# ENG-AASI18003-R1-CD-Redline-pgs.pdf Markup Summary

BRADLEY A. SIMONS 34705				
SHEET				
FM1.23

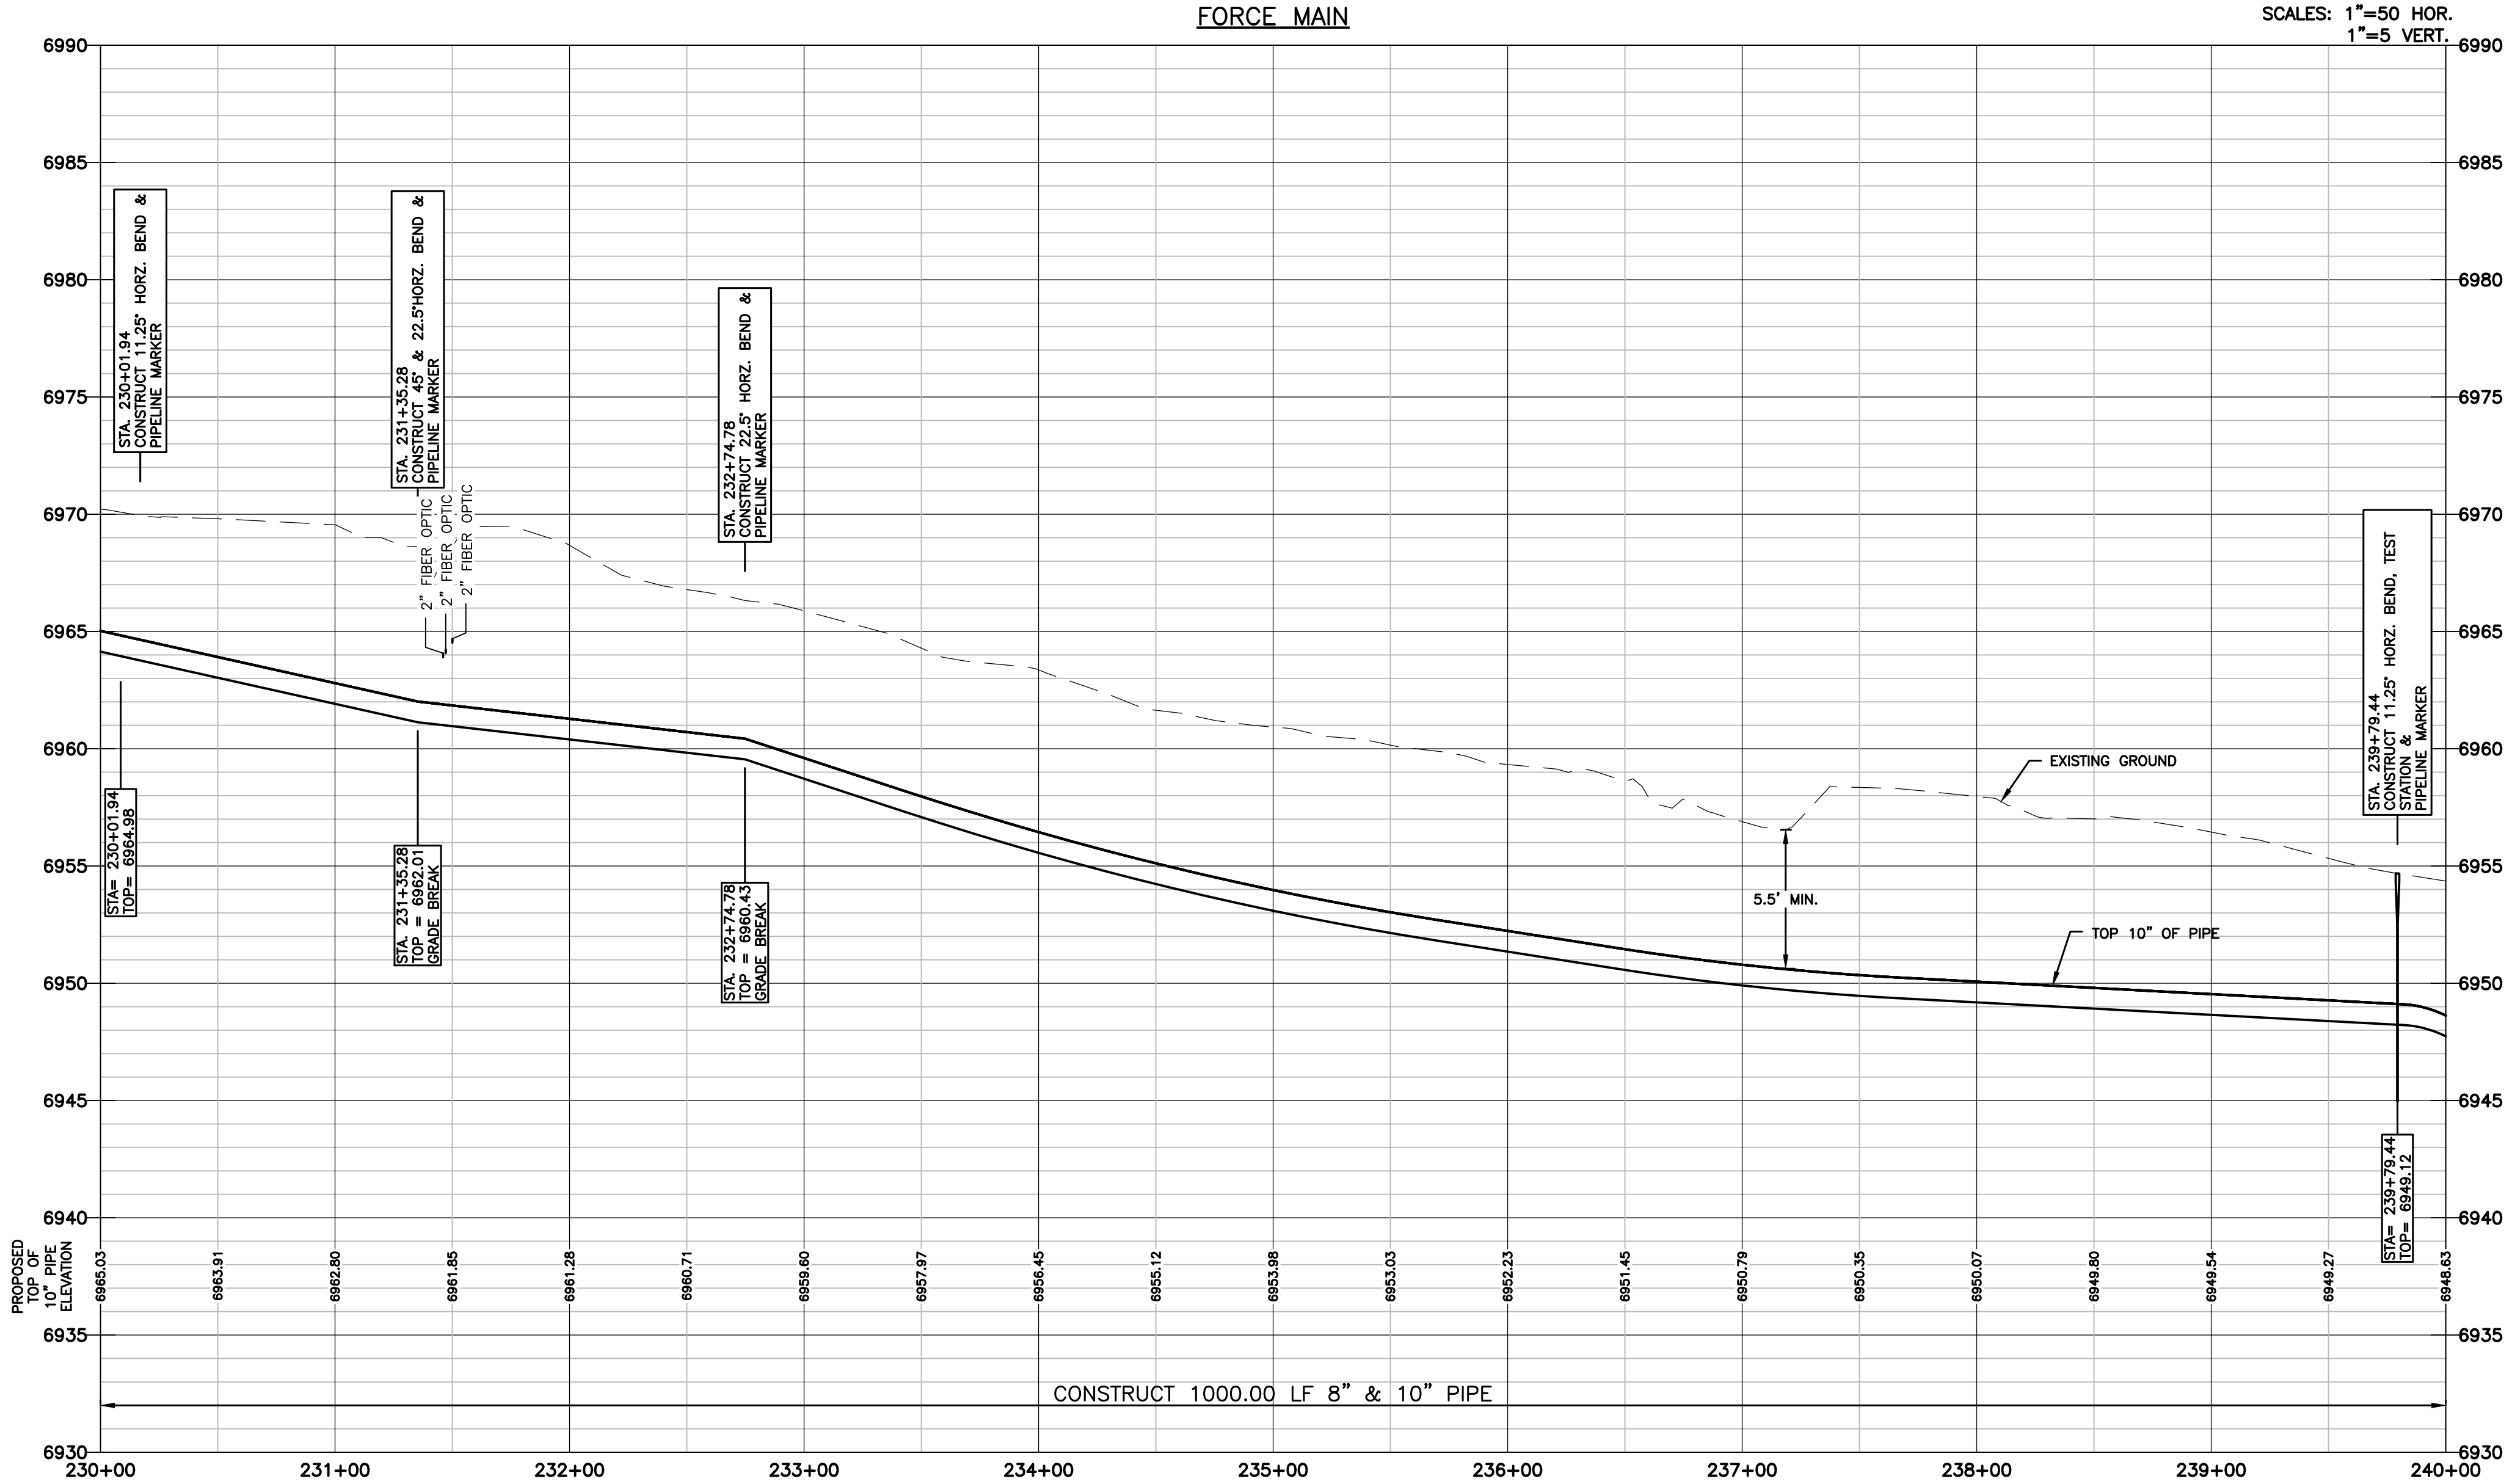
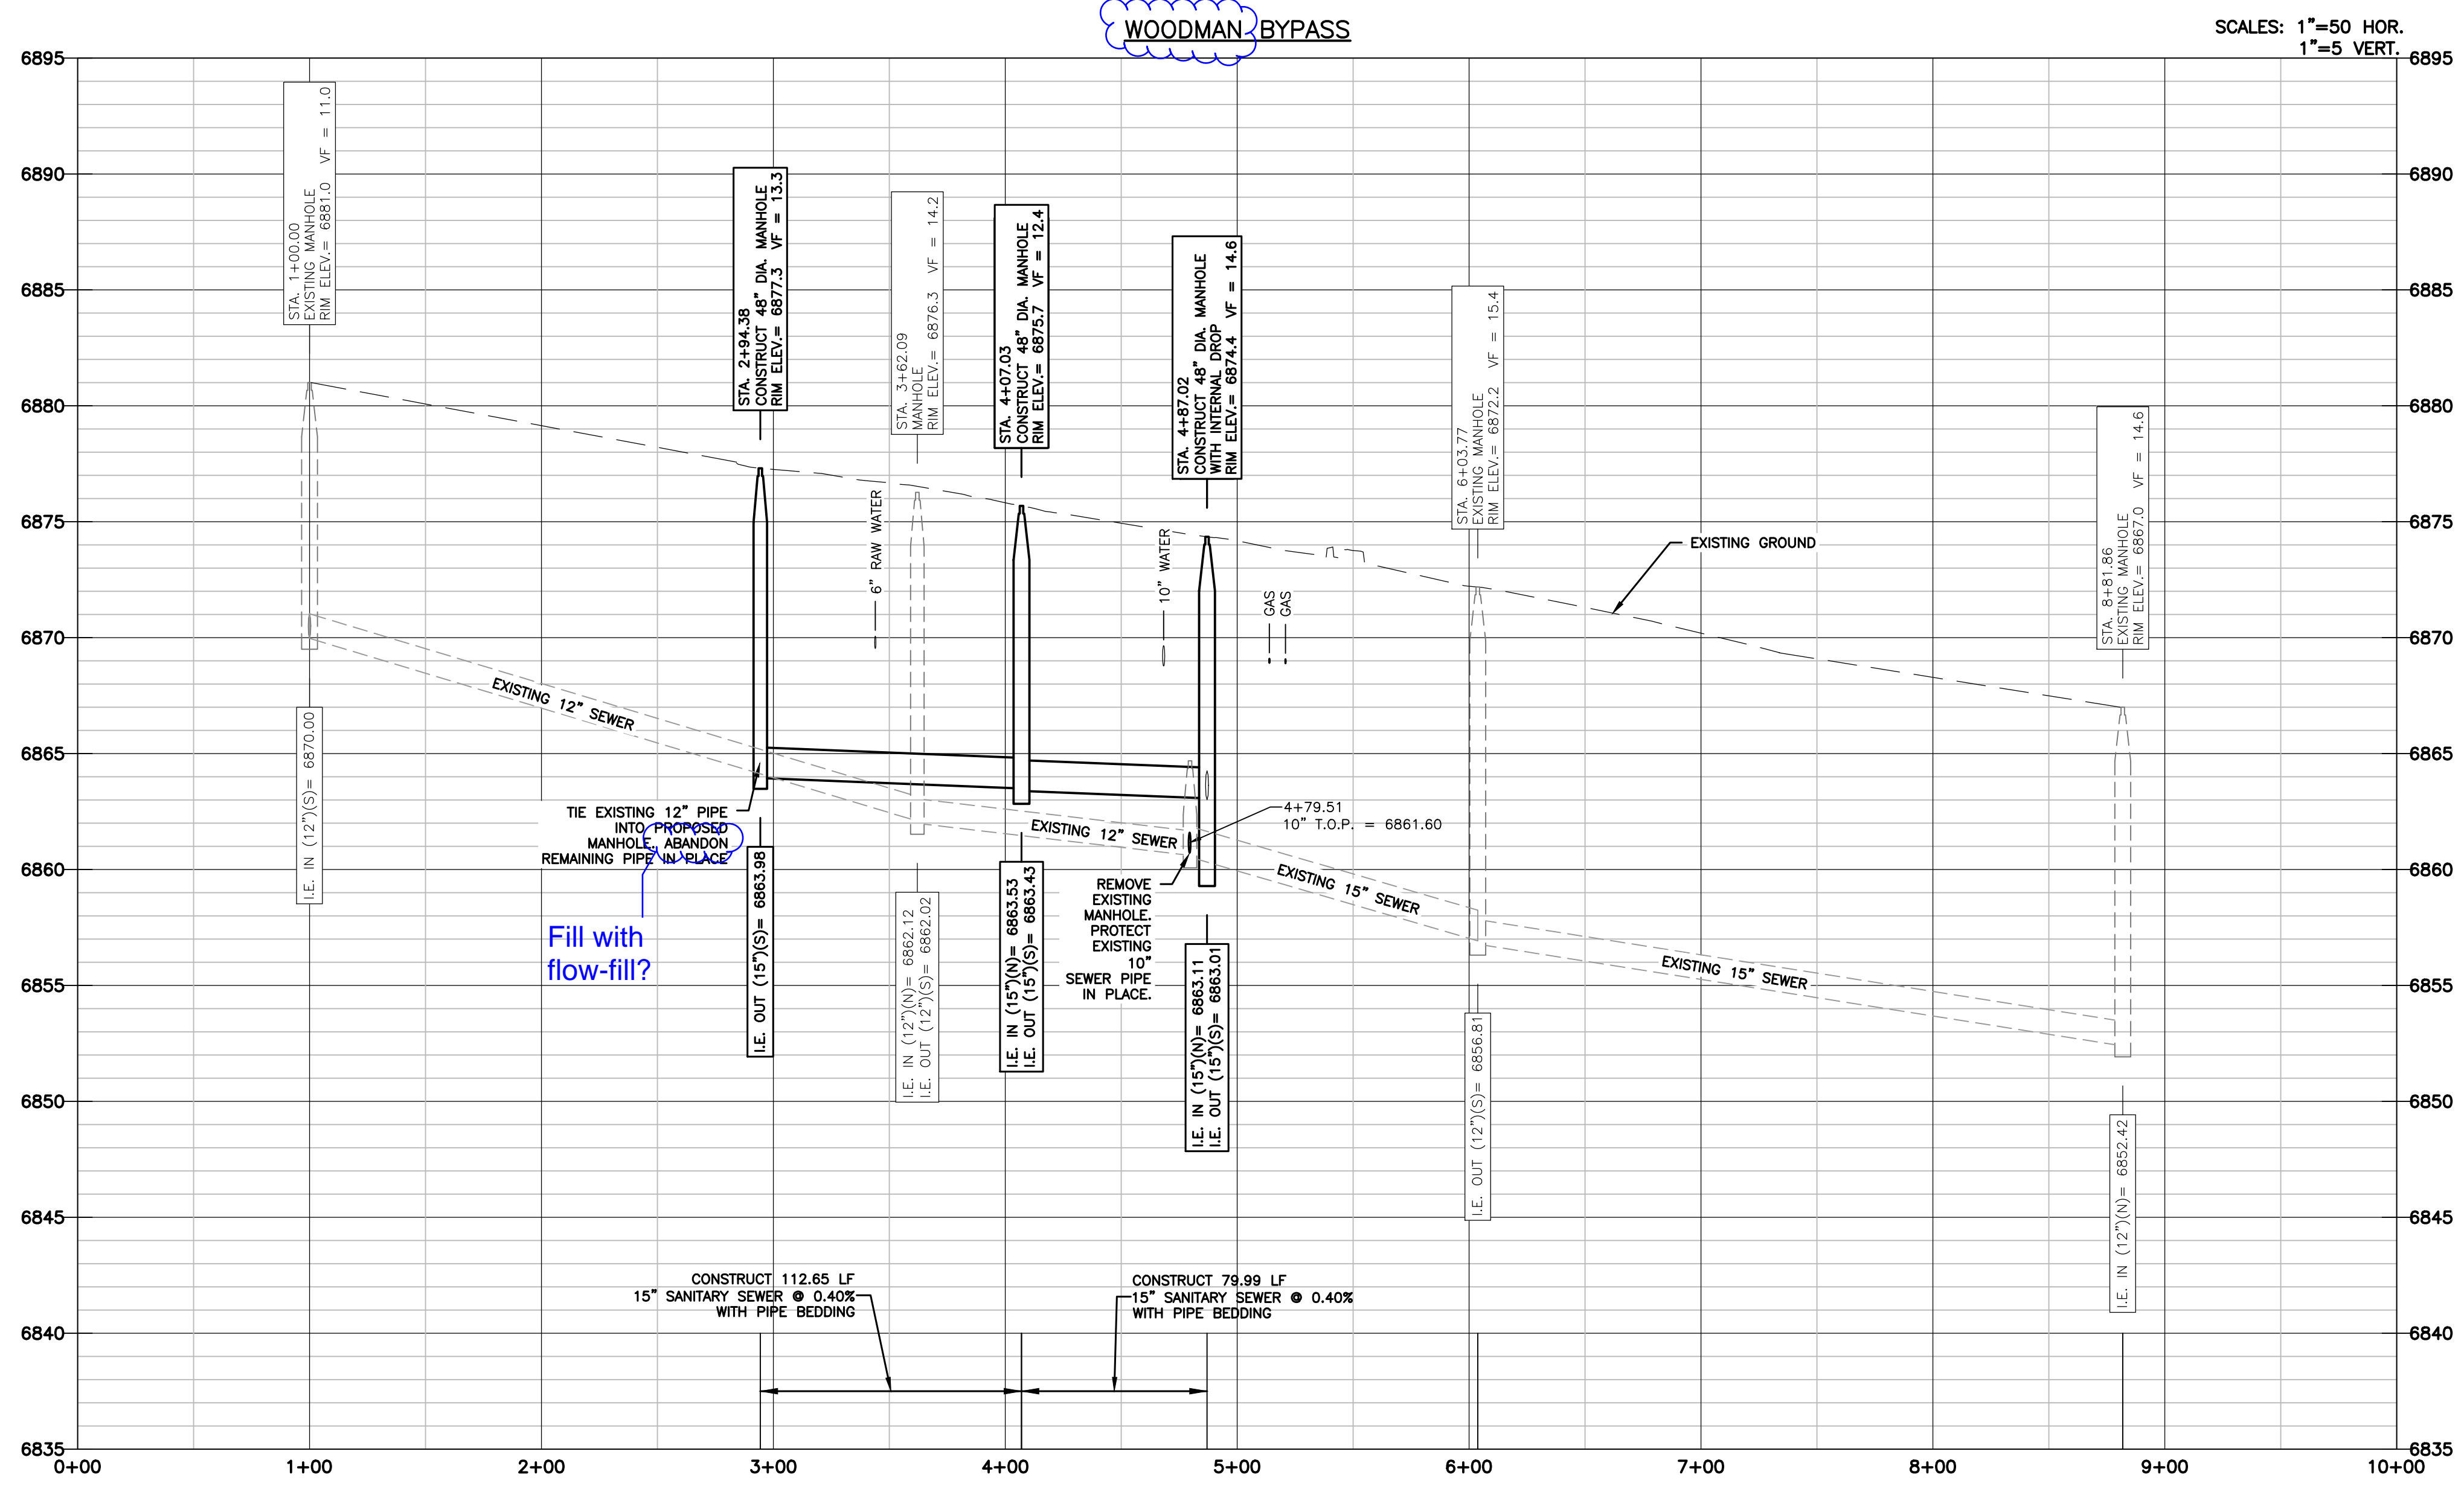
ultimate ditch?  
provide cross-sections
